KIRKLEES METROPOLITAN COUNCIL INVESTMENT & REGENERATION SERVICE

DELEGATED DECISION TO DETERMINE PLANNING APPLICATIONS

Reference No:	2024/62/92704/E
Site Address:	6, Garner Lane, Kirkburton, Huddersfield, HD8 0QX
Description:	Erection of two storey side extension and associated alterations (within a Conservation Area)
Recommending Officer:	Elenya Jackson

Officer Report

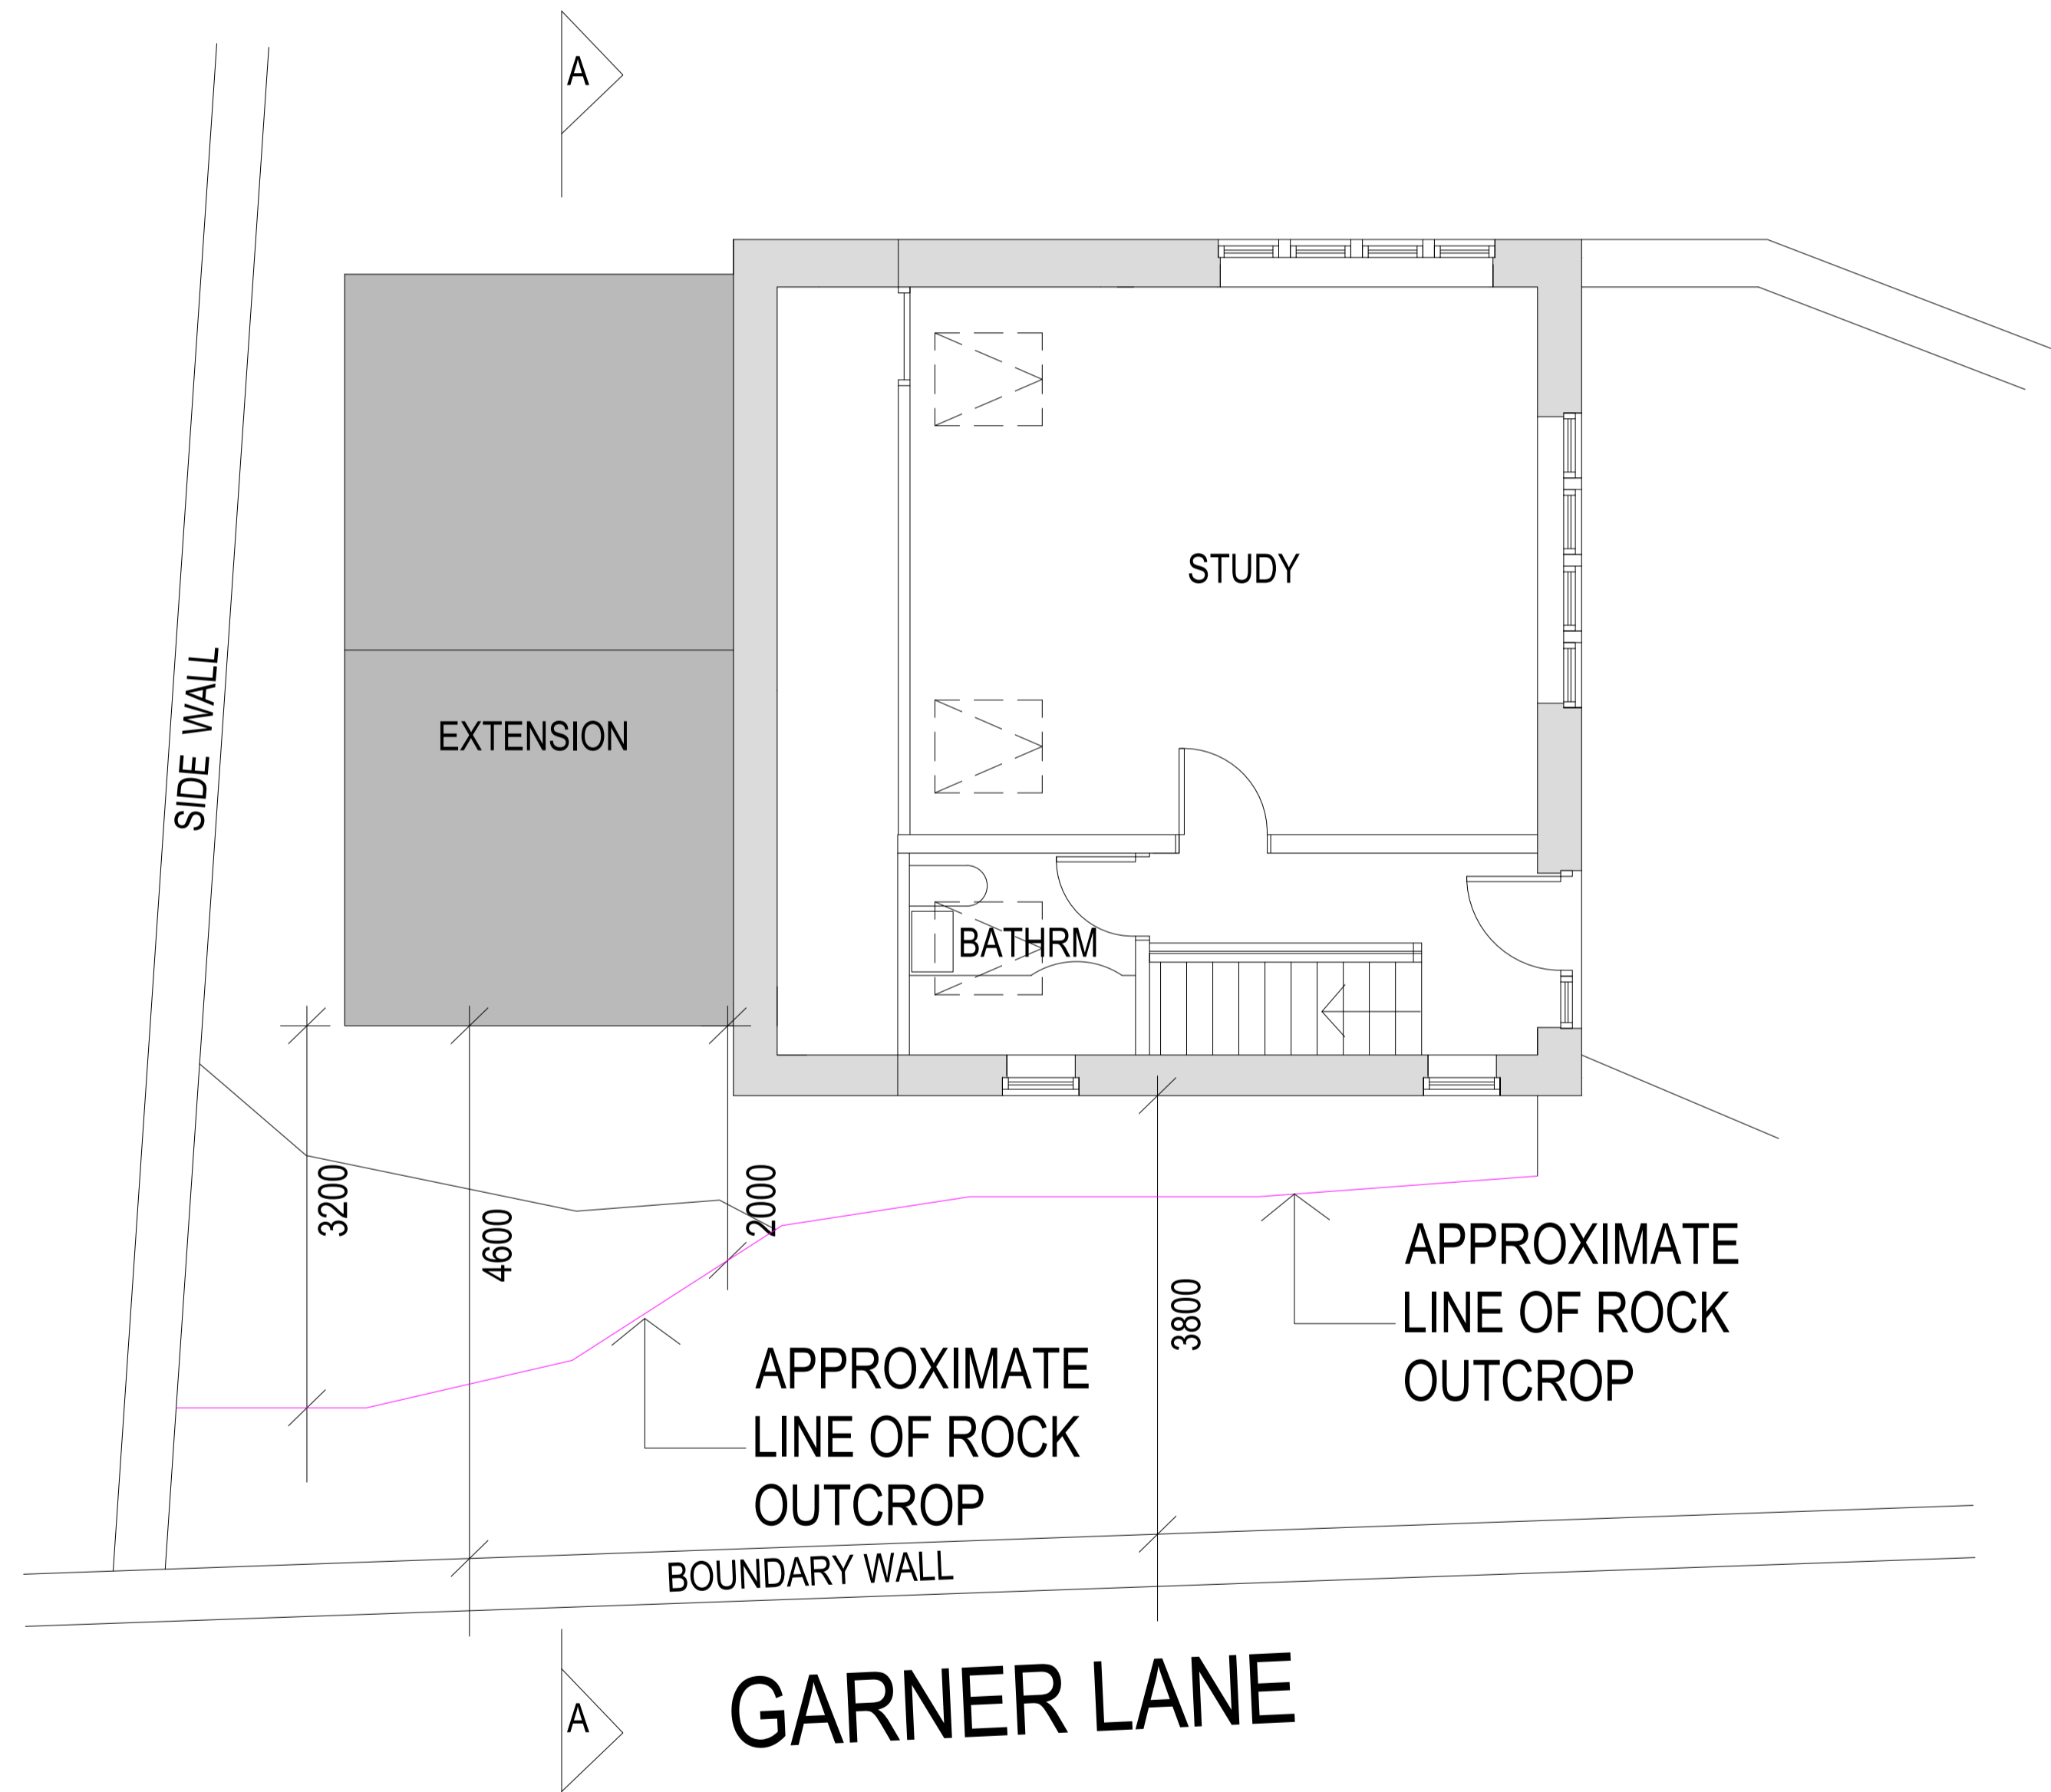
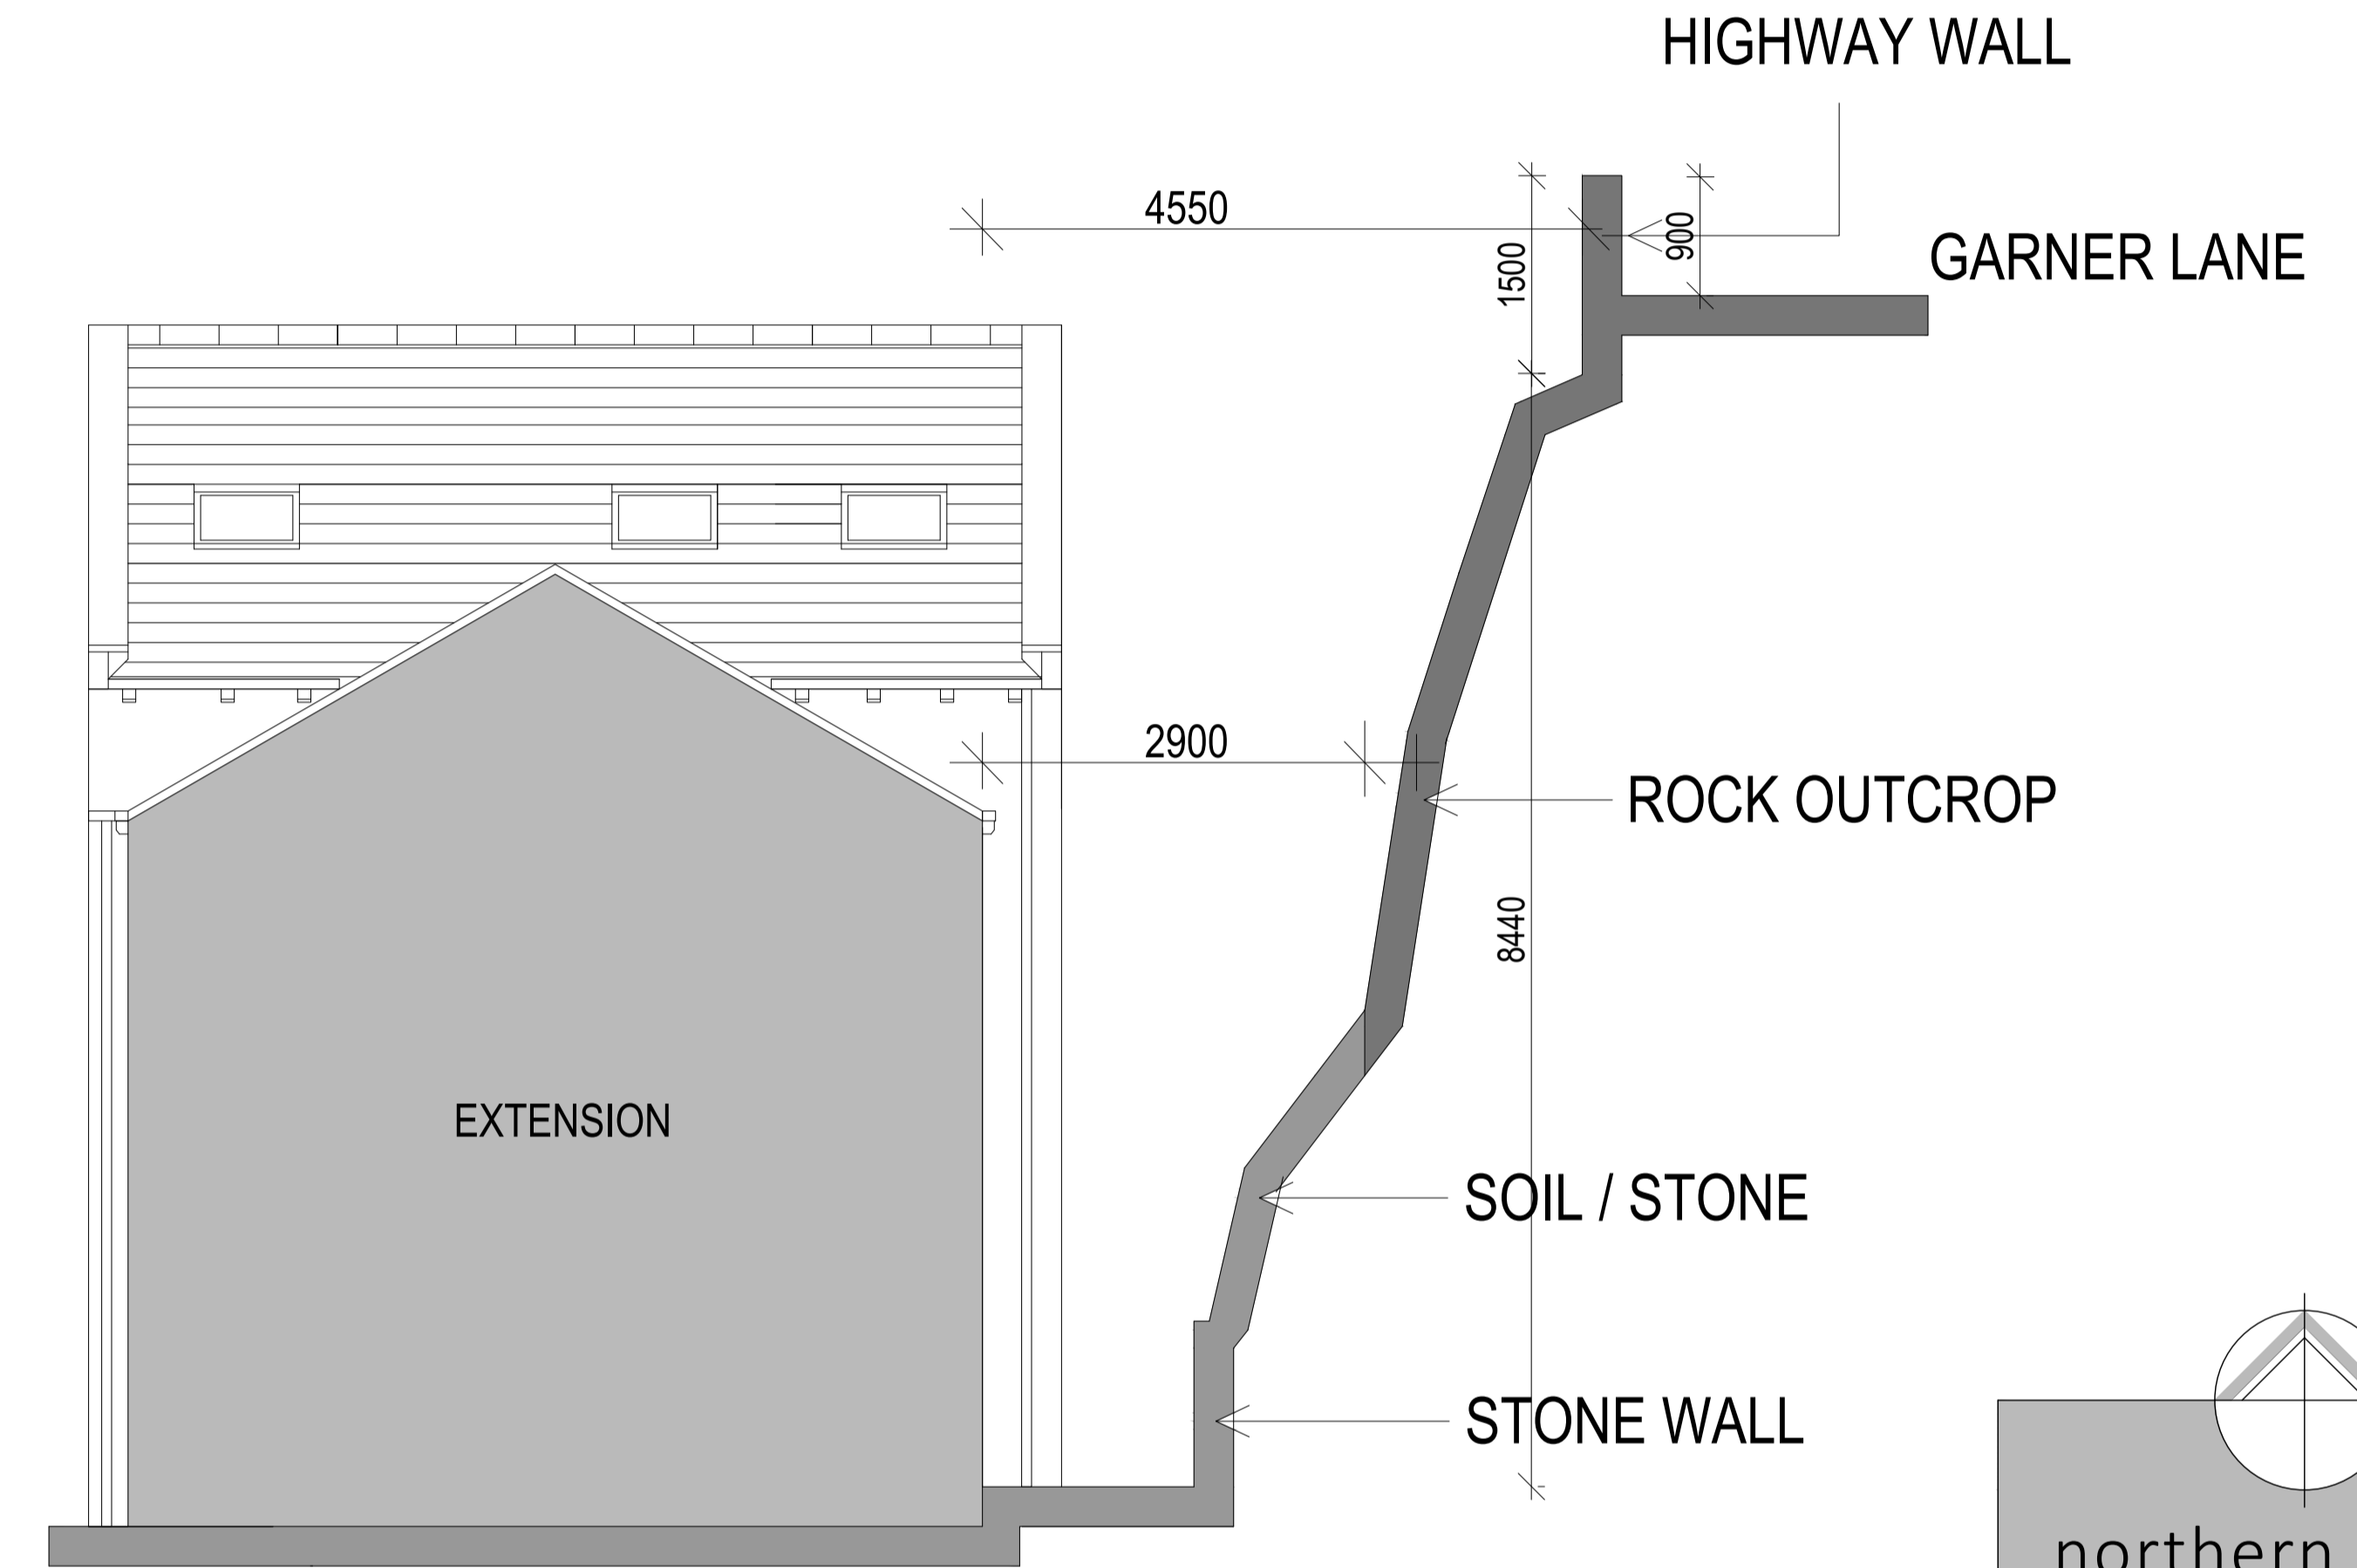
Officers requested further details regarding how the proposal would be constructed due to the dwellings proximity to the retaining wall which supports Garner Lane.

KC Highways Structures - Requested details relating to a cross section of the development and conditions relating to ongoing requirements for the retaining wall.

The proposal would require excavations next to the retaining wall which supports Garner Lane. As a result, highways structures have been consulted on the application. A cross section was requested during the course of the application and agreed in principle with the Council's structures team. However, in the event that planning permission be approved, further conditions are recommended to be attached relating to the provision of structural dilapidation surveys and a 3m easement strip for future maintenance of the wall.

Further details requested relating to the proposal's proximity to a structural retaining wall.

3. Before the development commences, a full structural dilapidation survey of the existing retaining wall supporting Garner Lane shall be undertaken by a suitably qualified and experienced structural engineer and a copy of the report submitted to the Highway Structures team for review. A further structural dilapidation survey of the retaining wall shall also be required following the completion of the works and any defects arising in the wall due to the works associated with the proposed development shall be made good to the satisfaction of the Council's Highway Structures team, at the developer's expense.

4. An easement strip of no less than 3.0m wide shall be retained between the proposed extension/ buildings and the existing retaining walls supporting Garner Lane to facilitate access for their future inspection and maintenance.
